## Portishead Branch Line (MetroWest Phase 1)

### 9.3.3 ExA.SoCG-EA.D3.V2 – Appendix 1 to Statement of Common Ground

**Response to the Planning Inspectorate's letter of advice under s 51 of the Planning Act 2008 and dated 24 January 2020  
Planning Act 2008**

**Date: March 2020**

2.41 - Easton-in-Gordano Flood Mitigation Plan

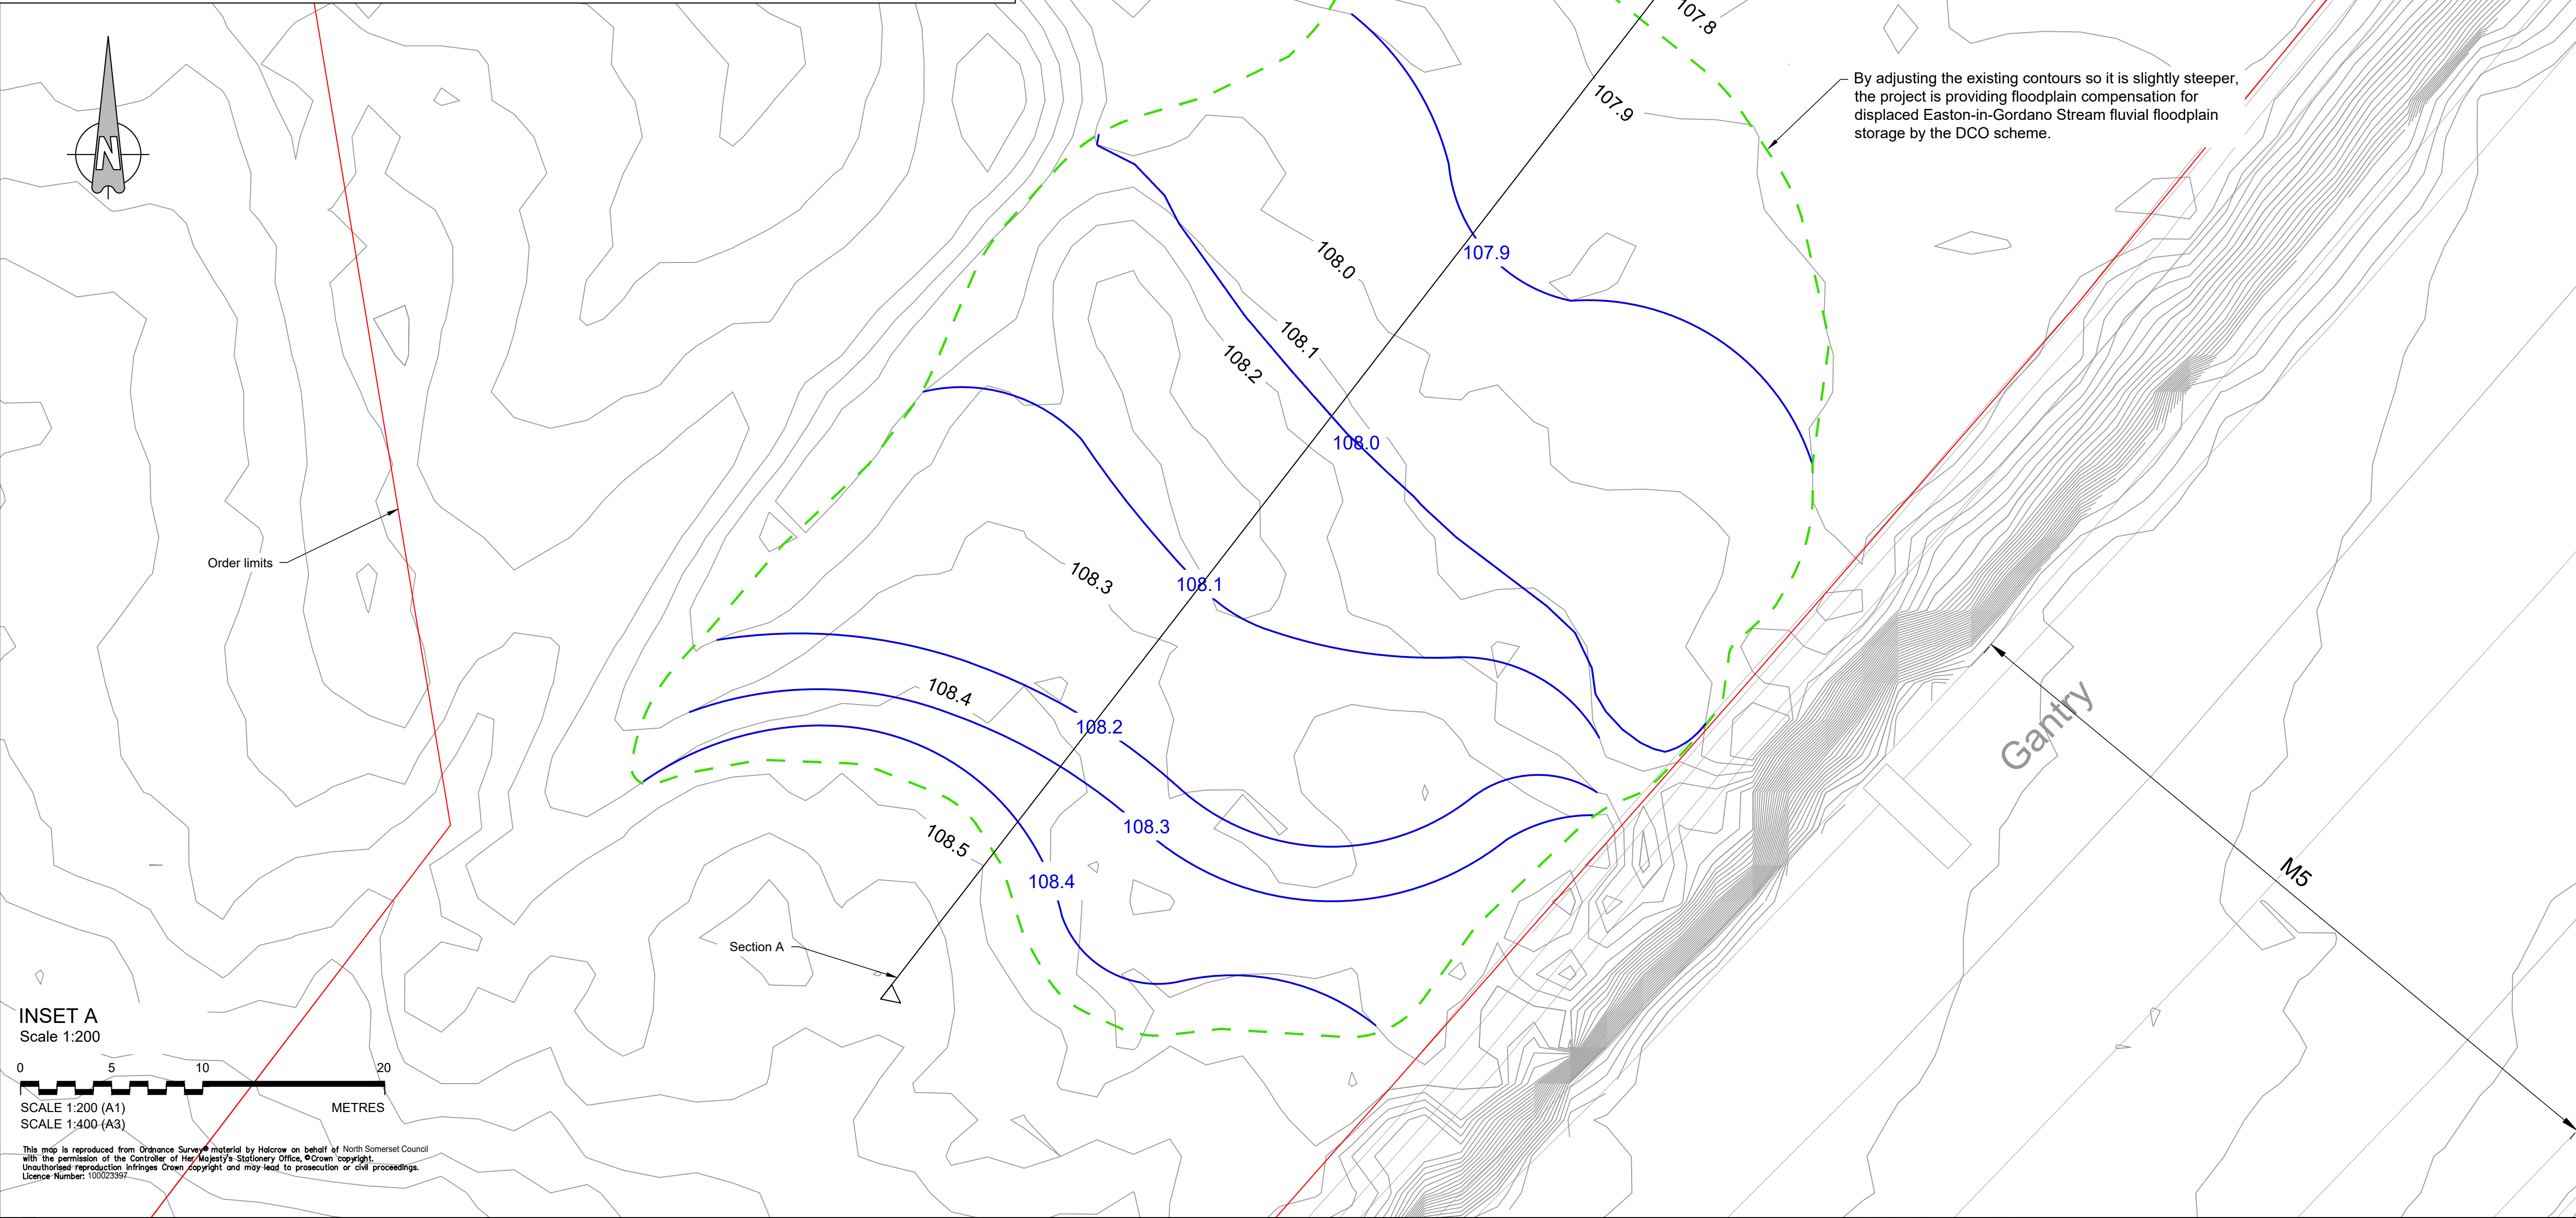
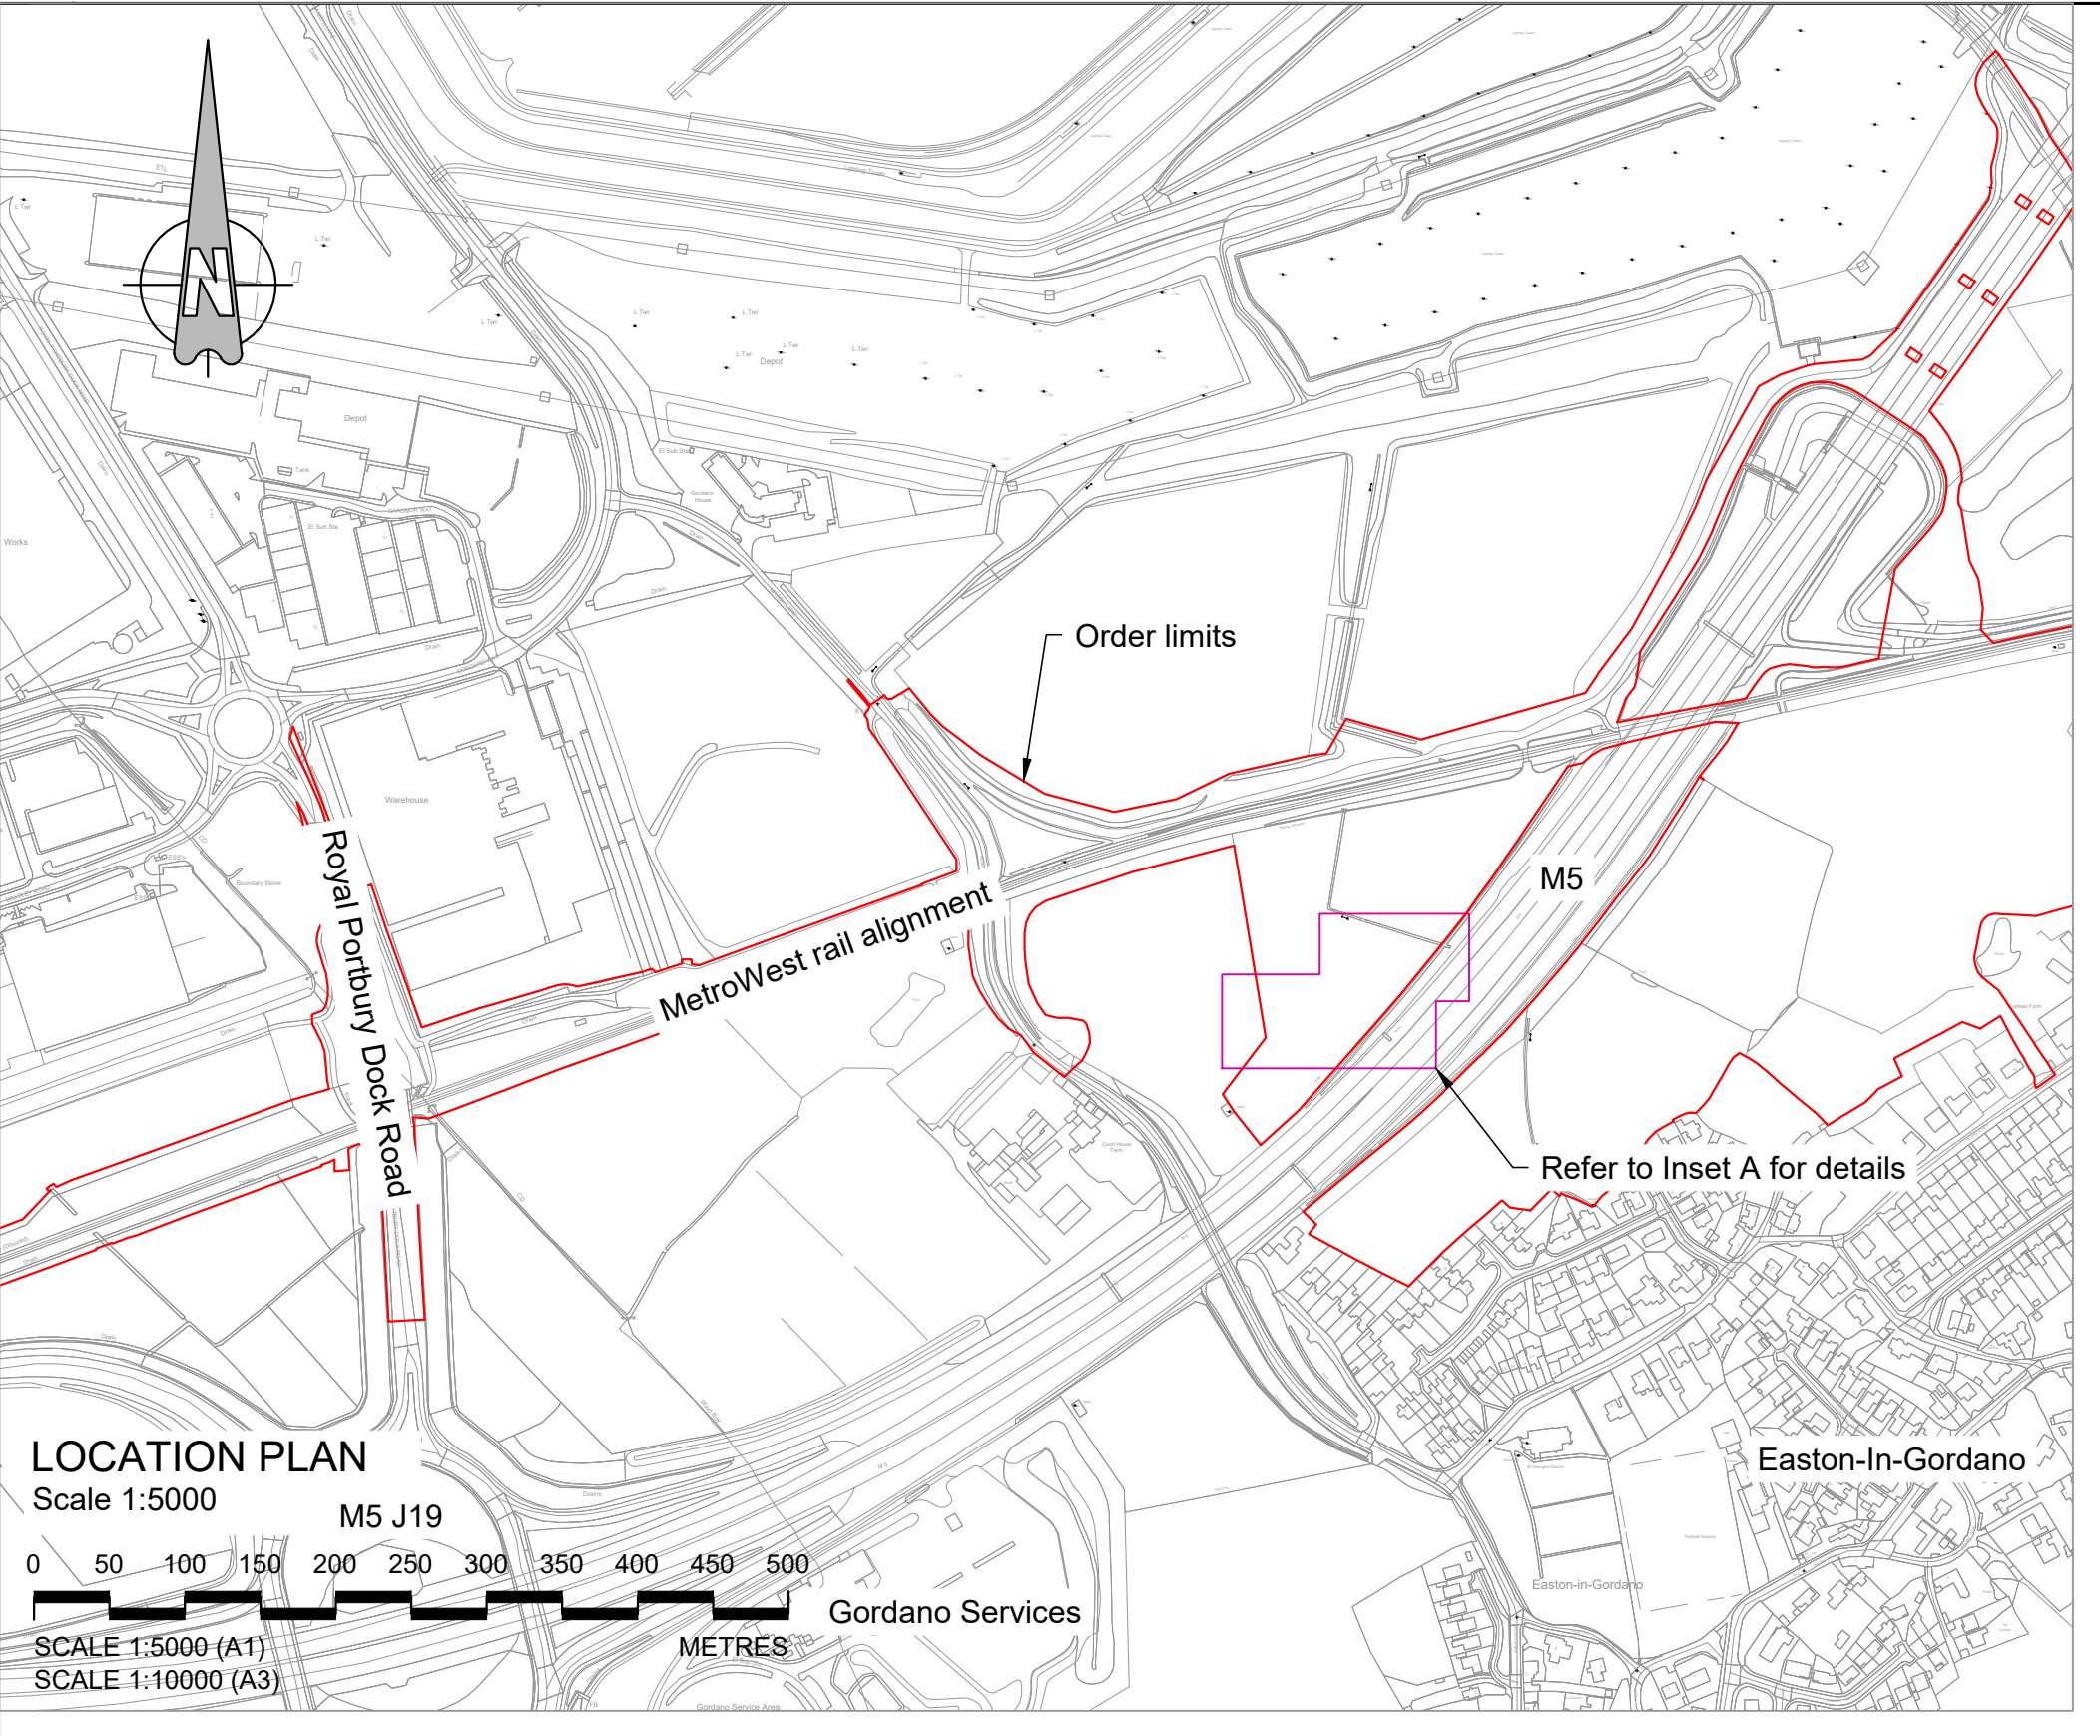
<p>The Applicant also proposes to increase the footprint of the railway embankment within the Easton-in-Gordano Stream floodplain which would result in displacement of potential floodplain storage, south of the railway. The Applicant therefore proposes floodplain storage compensation. In preparation for the examination the Inspectorate seeks to understand the extent to which the application of the revised climate change allowances may (or may not) affect the findings in this regard. In particular whether such detail would result in a need for increased levels of flood compensation to address greater levels of floodplain storage being displaced.</p>	<p><b>Section E</b></p> <p>The December 2019 NPPF Guidance on climate change guidance specifies for small catchments such as the Easton-in-Gordano Stream catchment (&lt;5km<sup>2</sup>) rainfall climate change allowances should be applied rather than river flow allowances. Assessment of the central and upper end rainfall allowances is required (20% and 40% respectively for both the 2075 and 2115 simulated future years). As mentioned above, the MetroWest Phase 1 FRA modelling of Easton-in-Gordano Stream applies a 20% climate change allowance for 2075 and 30% allowance for 2115.</p> <p>We have now undertaken simulations applying the December 2019 NPPF Guidance upper end climate change allowance (applying 40% uplift for both the 2075 and 2115 simulated future years). Results of these simulations show that the proposed floodplain storage compensation within the Easton-in-Gordano Stream floodplain does provide mitigation when applying the current upper end climate change allowance of 40%.</p> <p>The proposed floodplain storage compensation provides compensation for fluvial flood events up to a peak level of 8.3mAOD. The simulated 100 year return period fluvial flood peak level with 40% climate change allowance is 8.28 mAOD in 2075 and 8.29 mAOD in 2115 i.e. no additional floodplain compensation is required beyond what is proposed in the DCO application.</p>
